Department of
Primary Industries

OUT13/9696

**Kurnell Port and Berthing Facility (Port Botany) (SSD_5353)
Response to exhibition of Environmental Impact Statement (EIS)**

Kurnell Port and Berthing Facility (Port Botany) (SSD_5353) Response to exhibition of the Environmental Impact Statement (EIS) Comment by Fisheries NSW

Figure 1-2: Modelled sediment deposition relative to places of important ecological value (URS 2013)

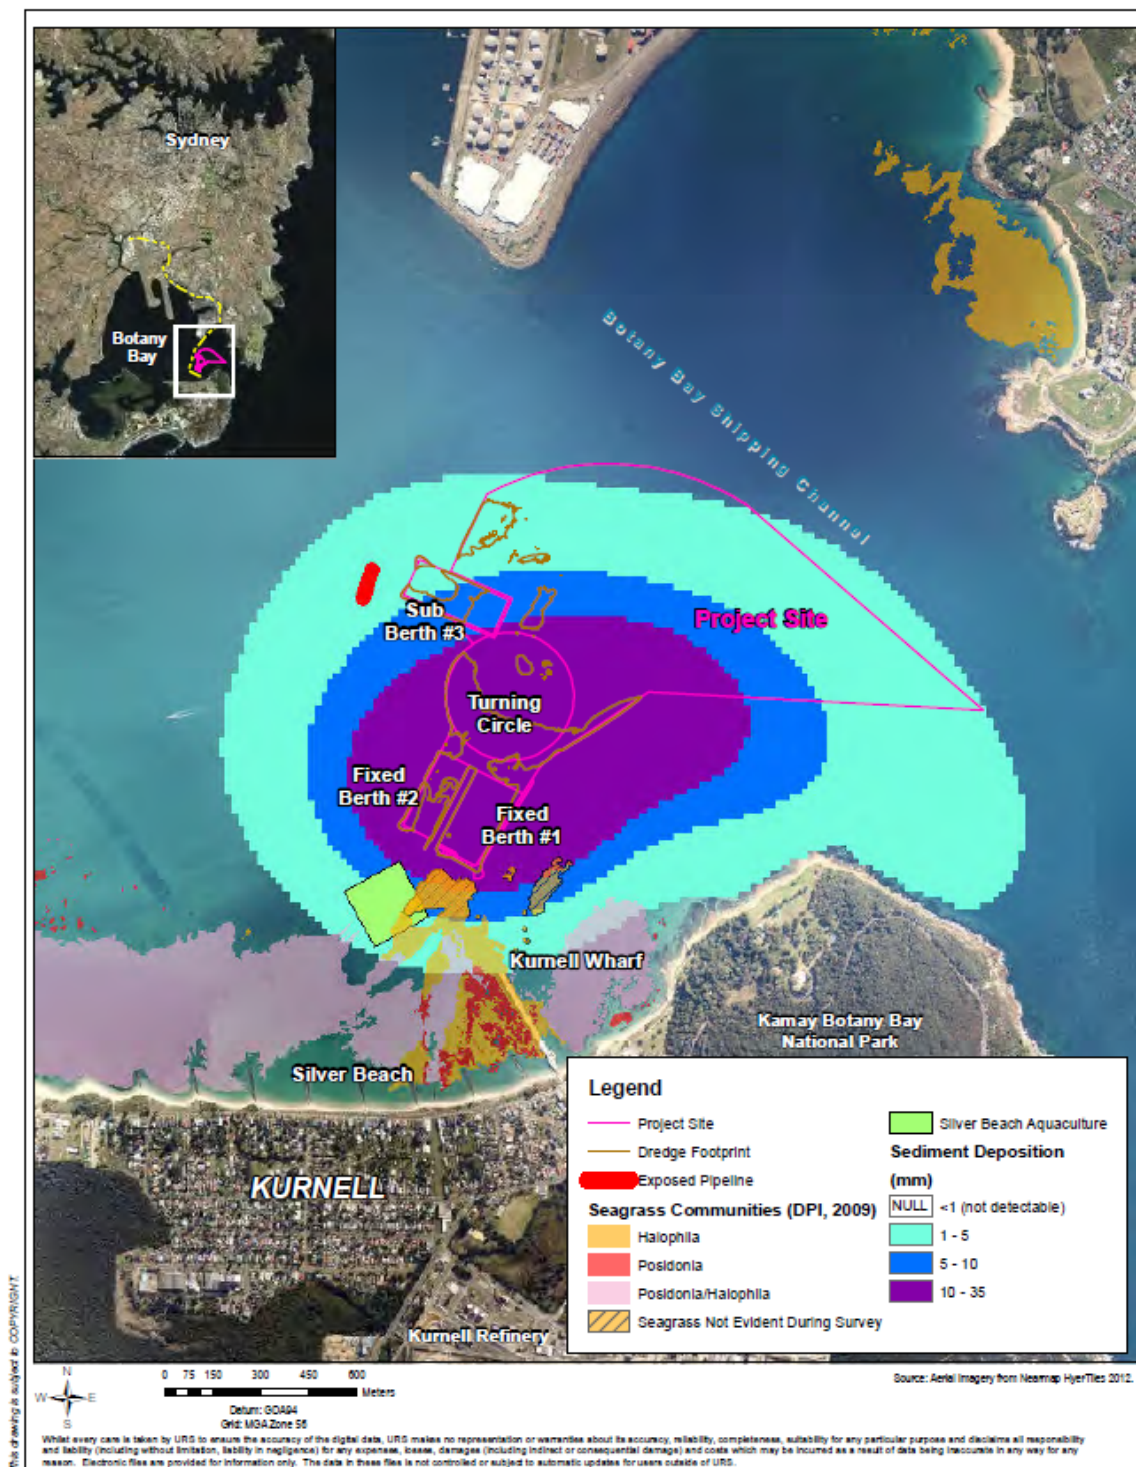
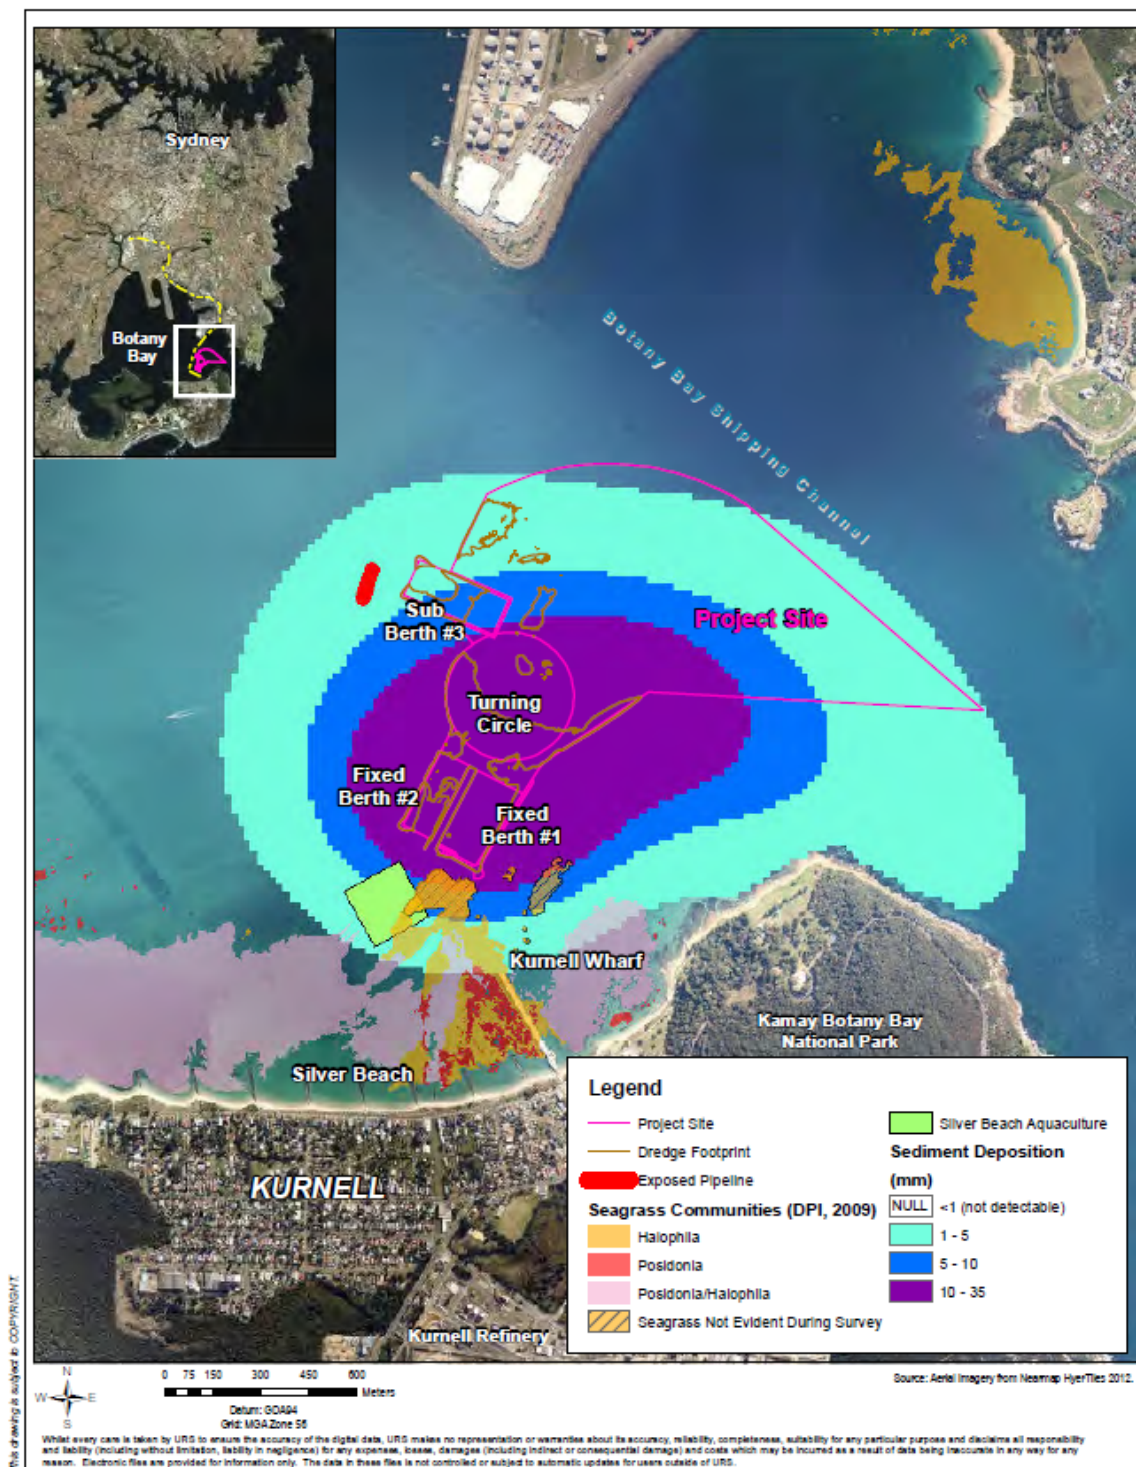
6. Part of the modelled sediment deposition over seagrass areas falls in the area of seagrass habitat where active remediation research is currently occurring following the harm resulting from AusGrid's Energy Cable Laying Project. Fisheries NSW scientists have been alerted of this and have asked to be kept informed of when the dredging activity will occur. The Department of Planning and Infrastructure is hereby advised of this request, and it is also recommended that comment is also sought from AusGrid on this matter.

Figure 8-1: Location of sediment and water quality monitoring points

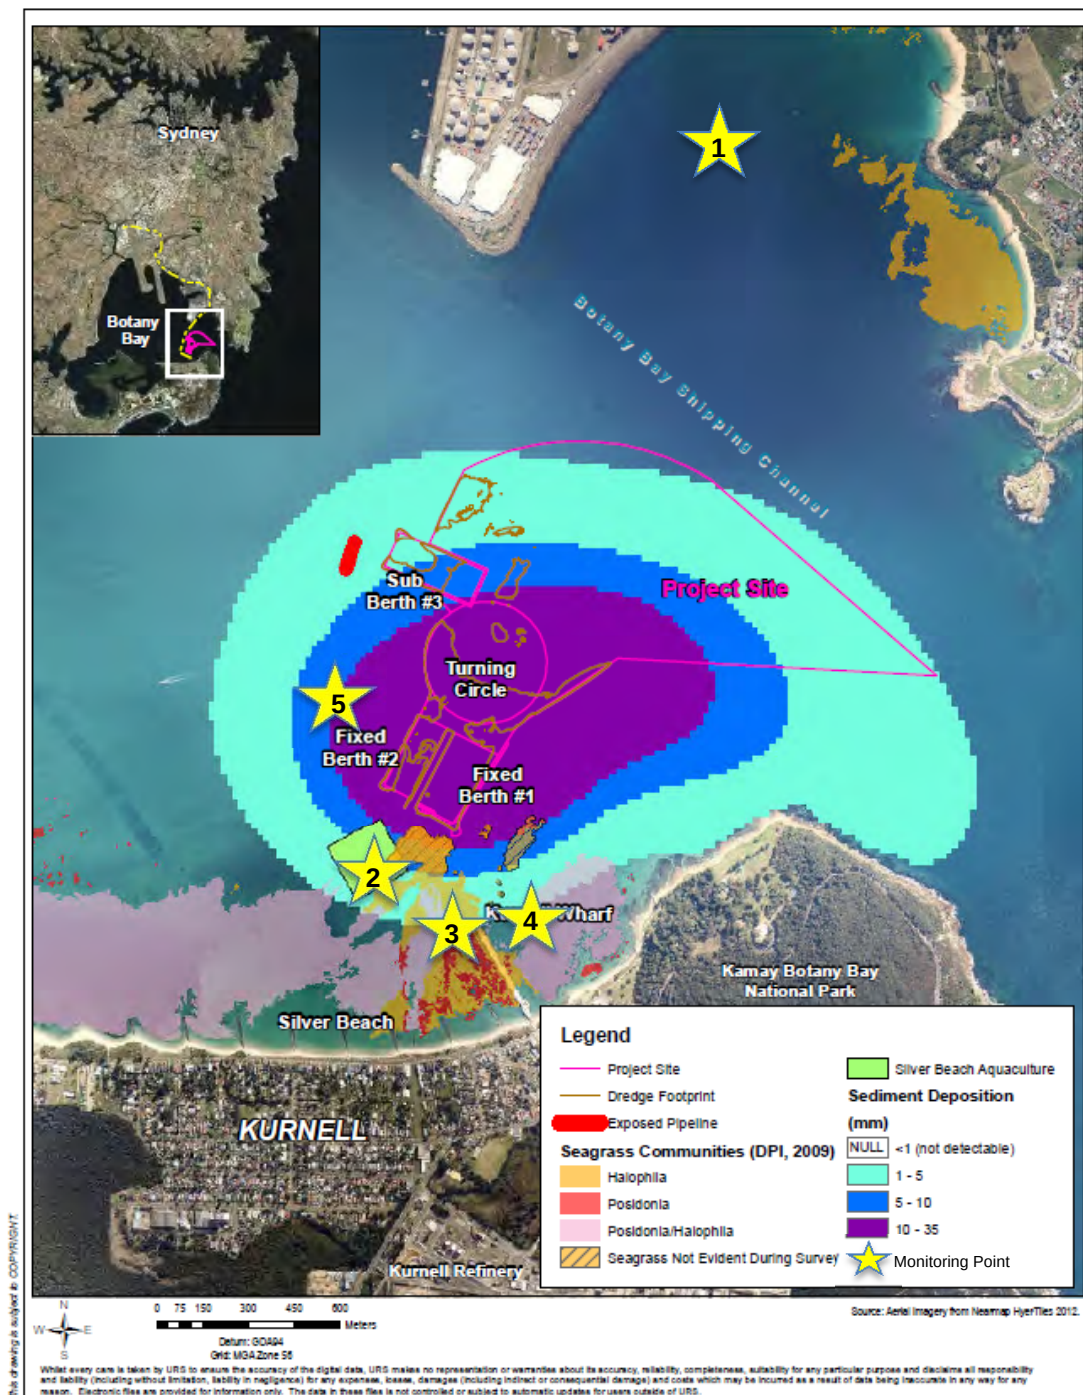
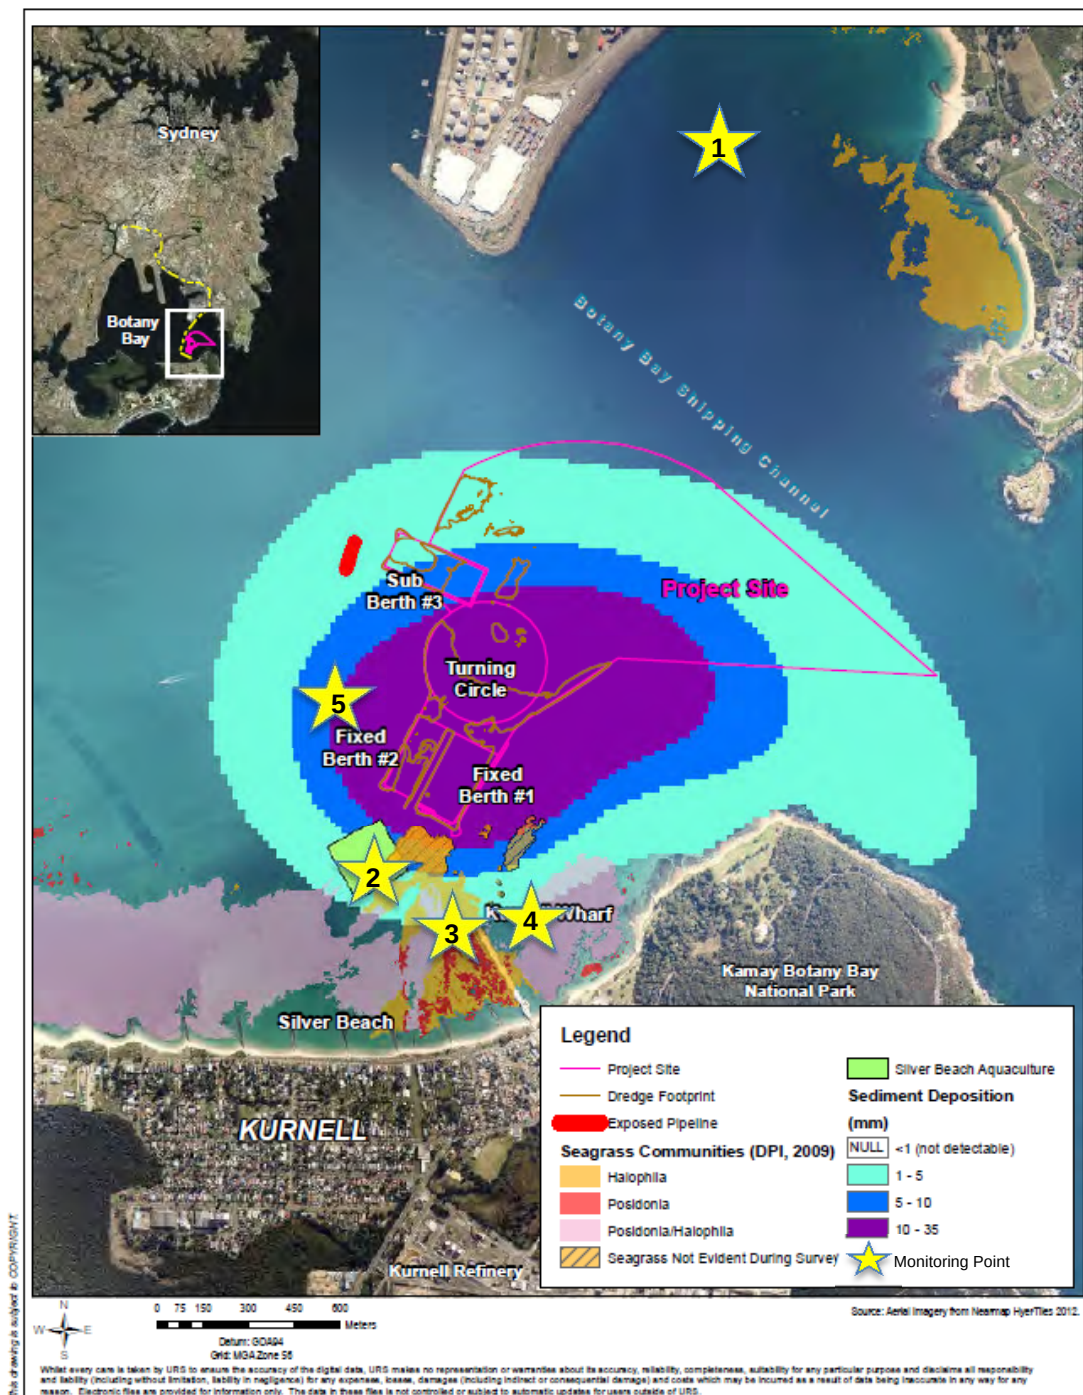
- (b) the live monitoring of turbidity levels needs to occur at several locations along the northern portion of the nearby seagrass bed. These sites need to include areas of the Endangered Population of *Posidonia australis* seagrass.

Figure 4-2: Dredge footprint and “no overflow dredging” areas

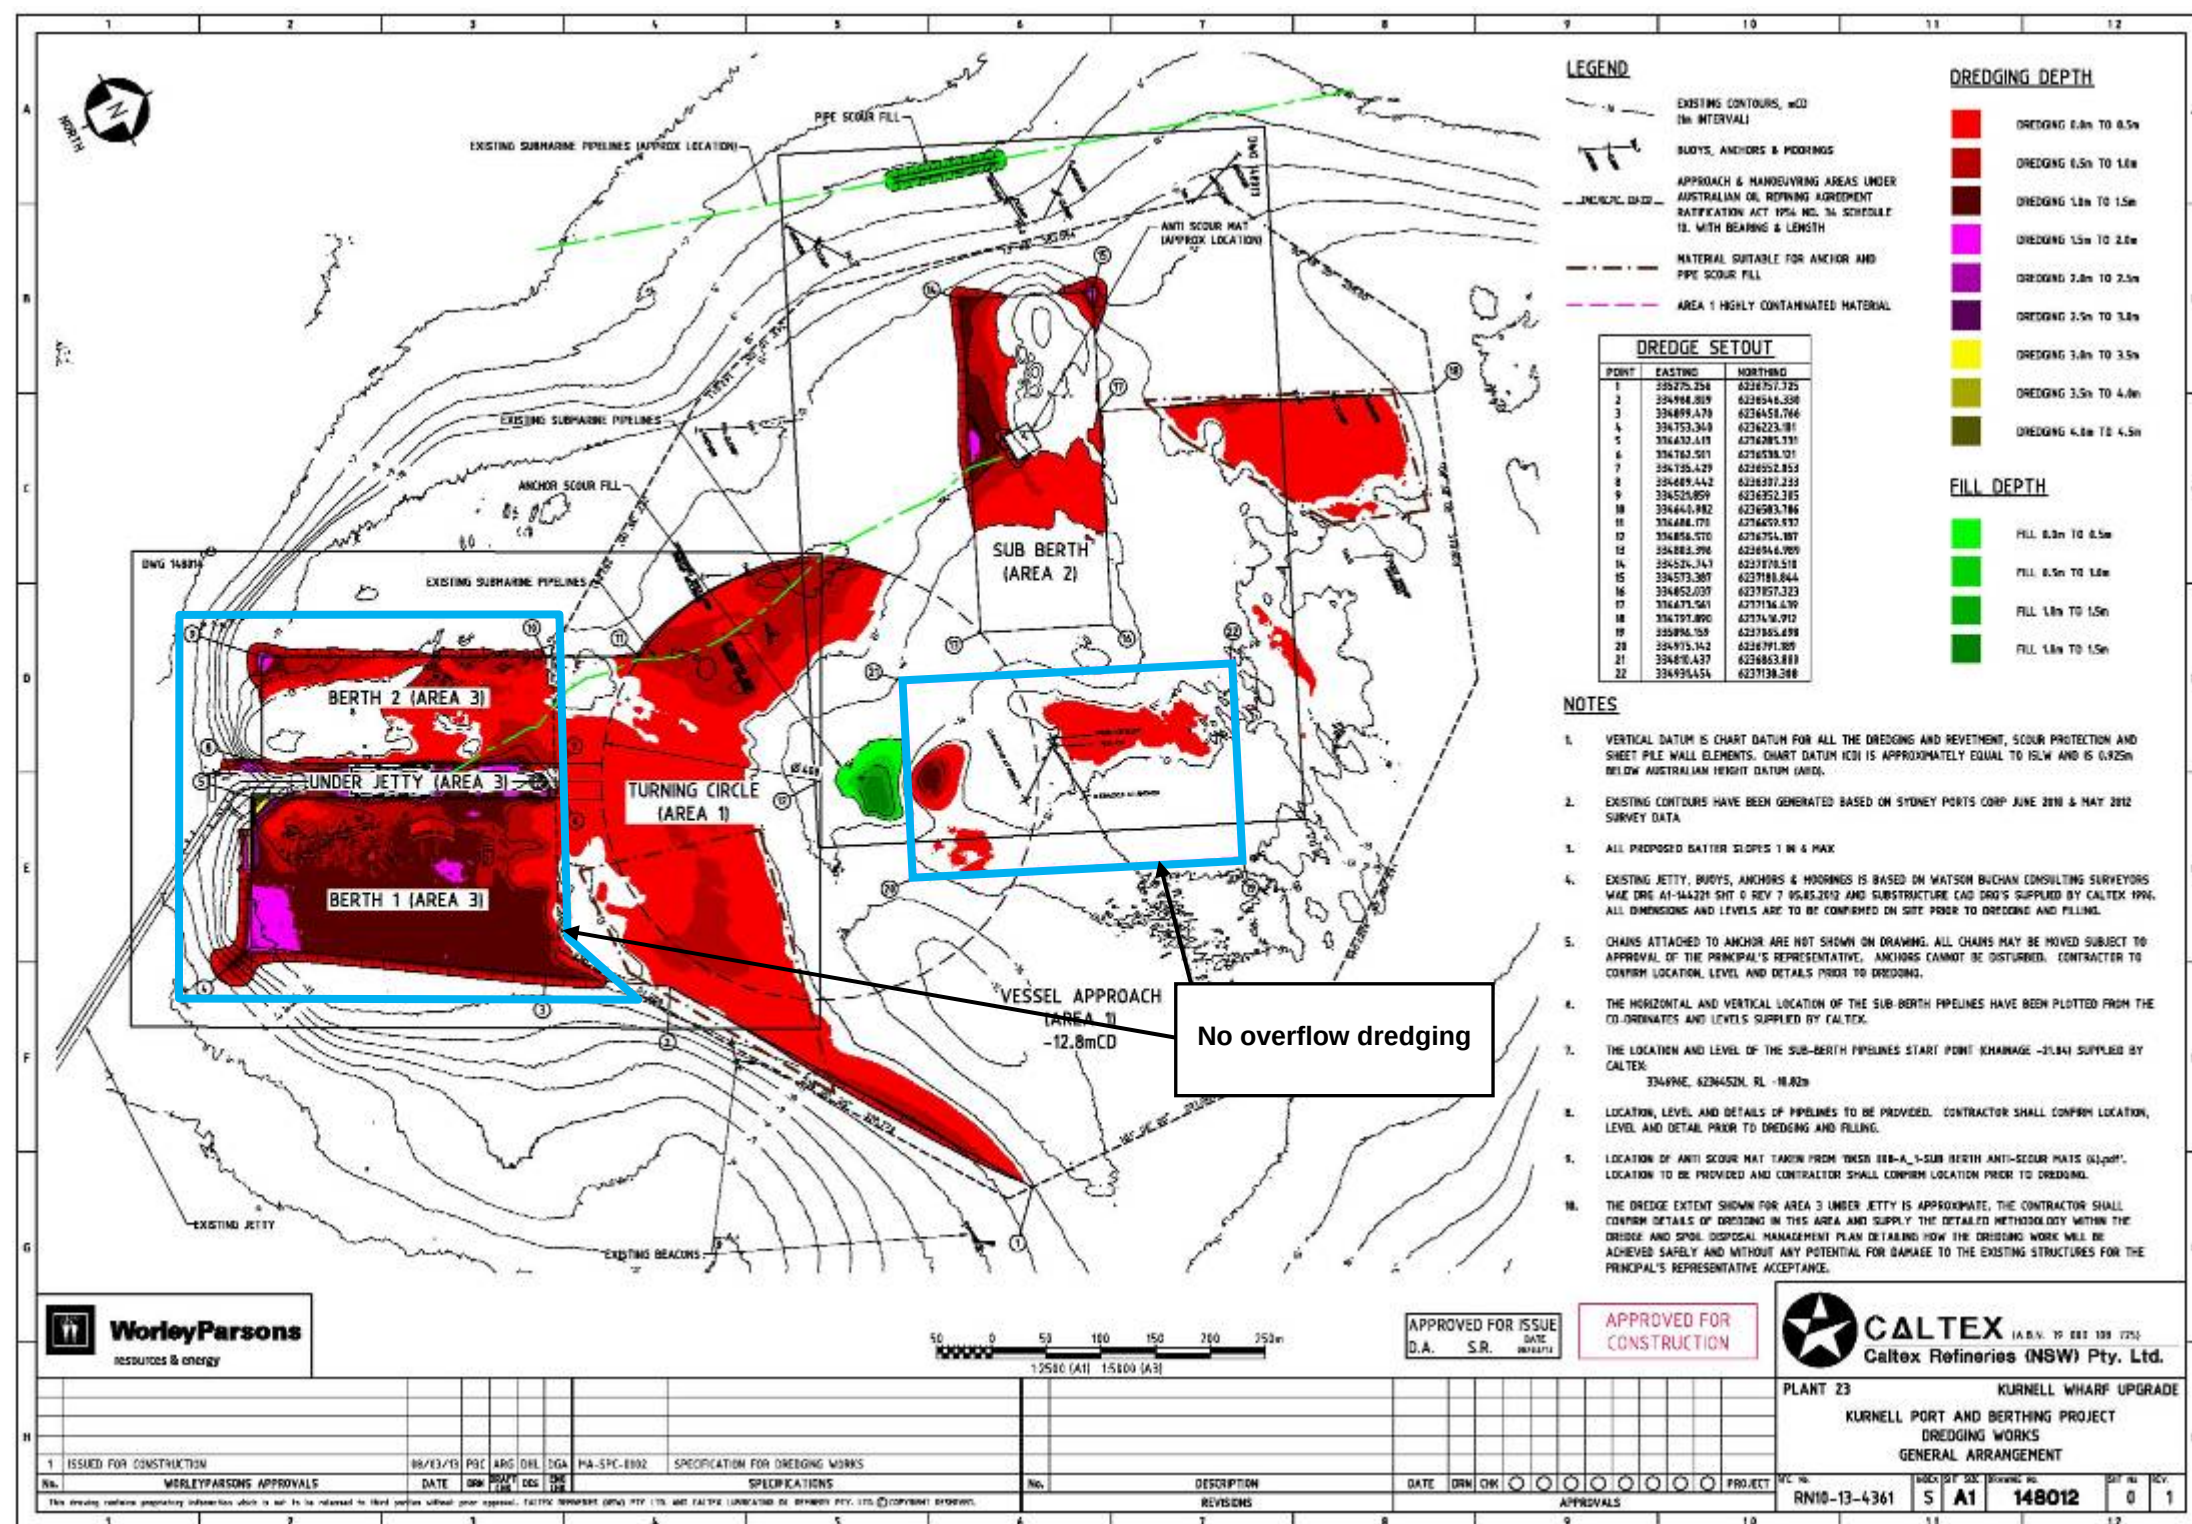
- (c) the management measure not to undertake "overflow dredging" within fixed berthing areas (p.4-9 of the EIS) be supported. However, to further avoid impacts to nearby seagrasses, dredging works within the fixed berthing areas should also, if at all possible, be staged to avoid the spring-summer seagrass growth season.
